Our Ref: AB/24/10/L

Application for Listed Building Consent for alterations to stables/coach house including converting garage into habitable room internal alterations replacing double timber doors with window and replacing aluminium patio door with painted timber french windows.

Stables/Coach House Adjacent 4 Park Place Arundel

PROJECT		Alterations to Coach House at 4 Park Place Arundel.	
SUBJECT		Proposed plans and Elevations	
SCALE	1:50	DATE	Feb 2010
DRAWN		CHECKED	
		DRAWING No.	10 / 12 / 02 A

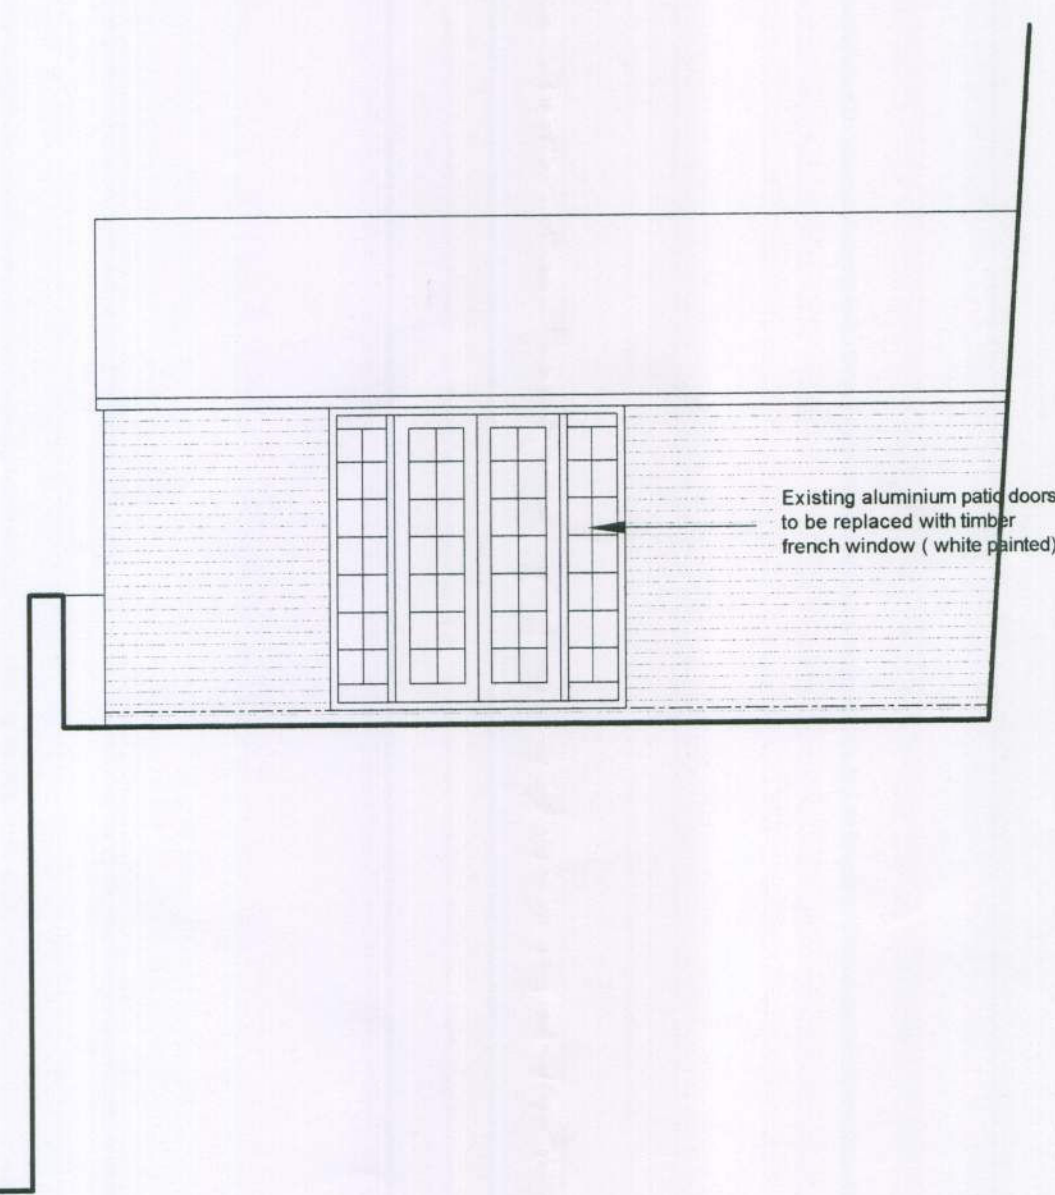
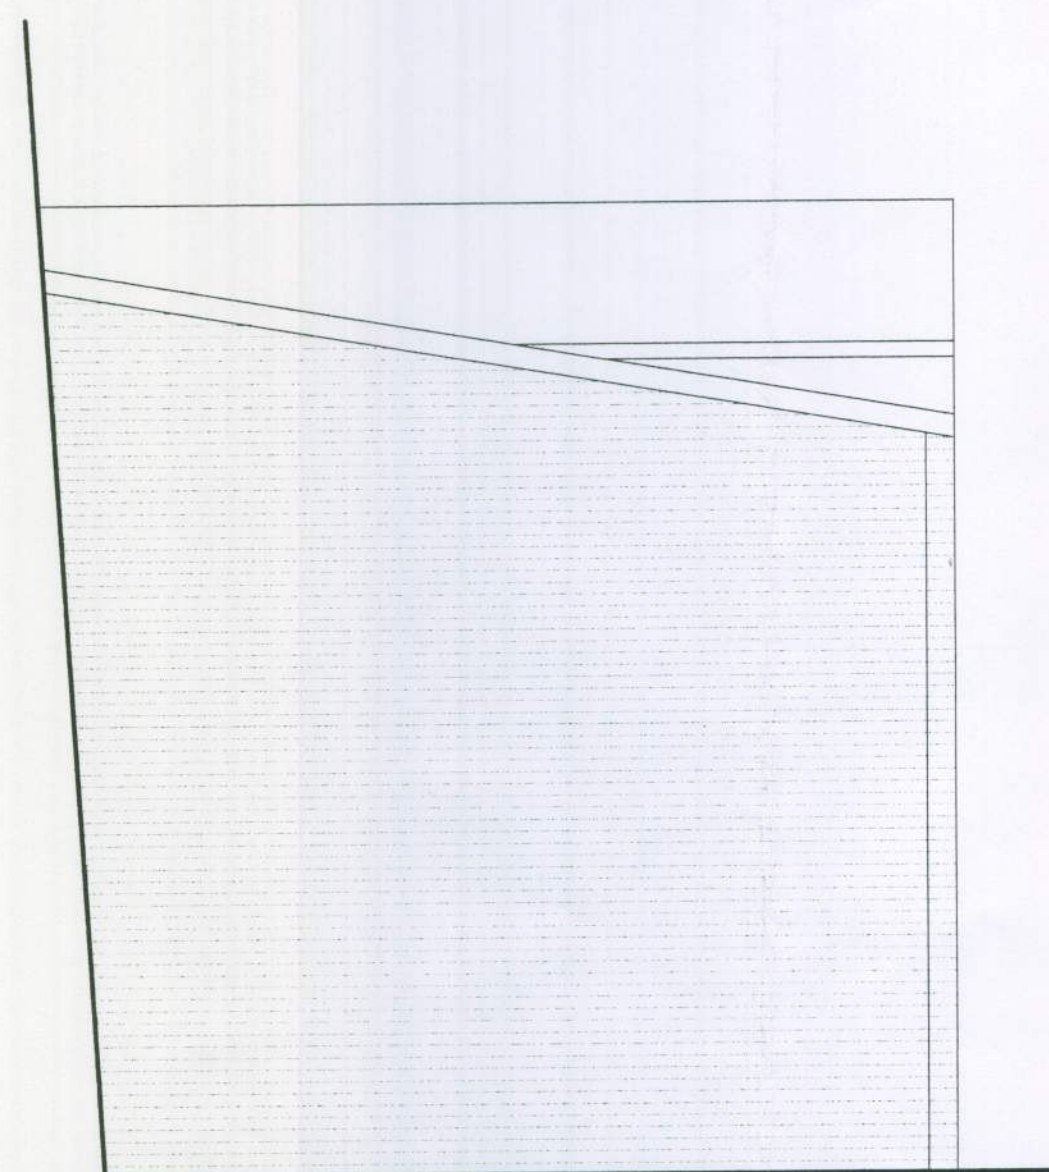
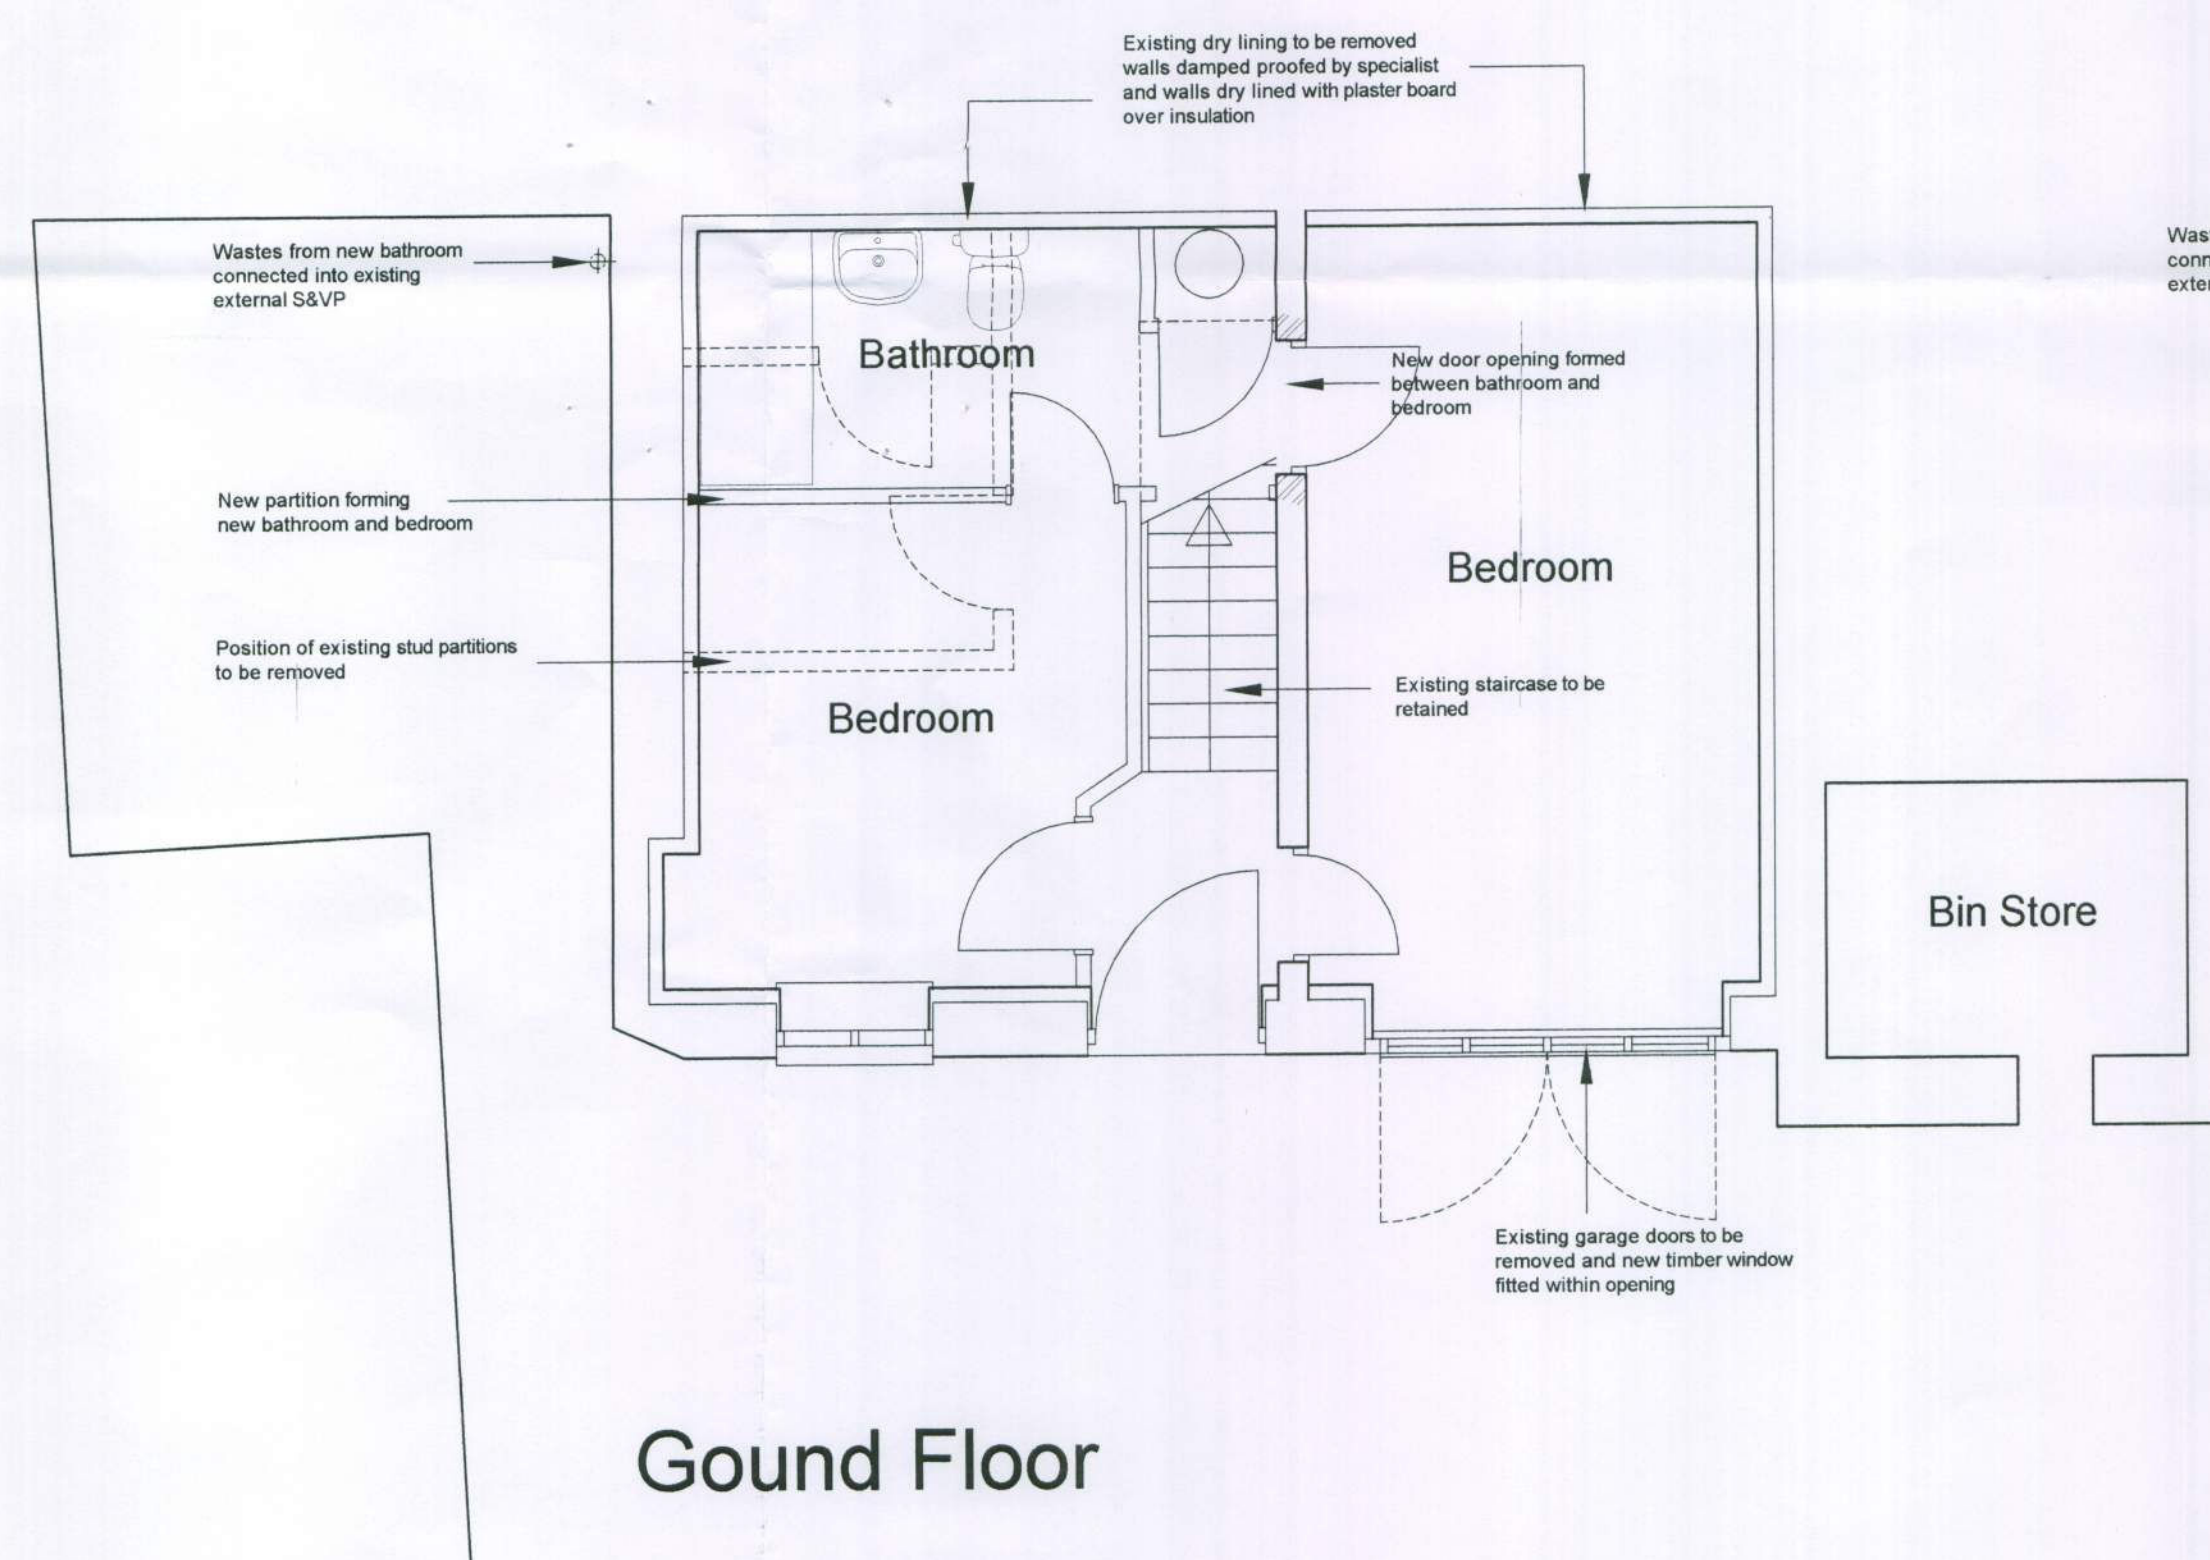
The Committee objects to the application on the grounds that the conversion of that part of the front elevation which currently comprises the garage door is unsympathetic to and fails to reflect the important appearance, size and style of the other openings and features characteristic of this listed building. The proposal fails to preserve or enhance the character or appearance of the host dwelling or its conservation area surroundings.
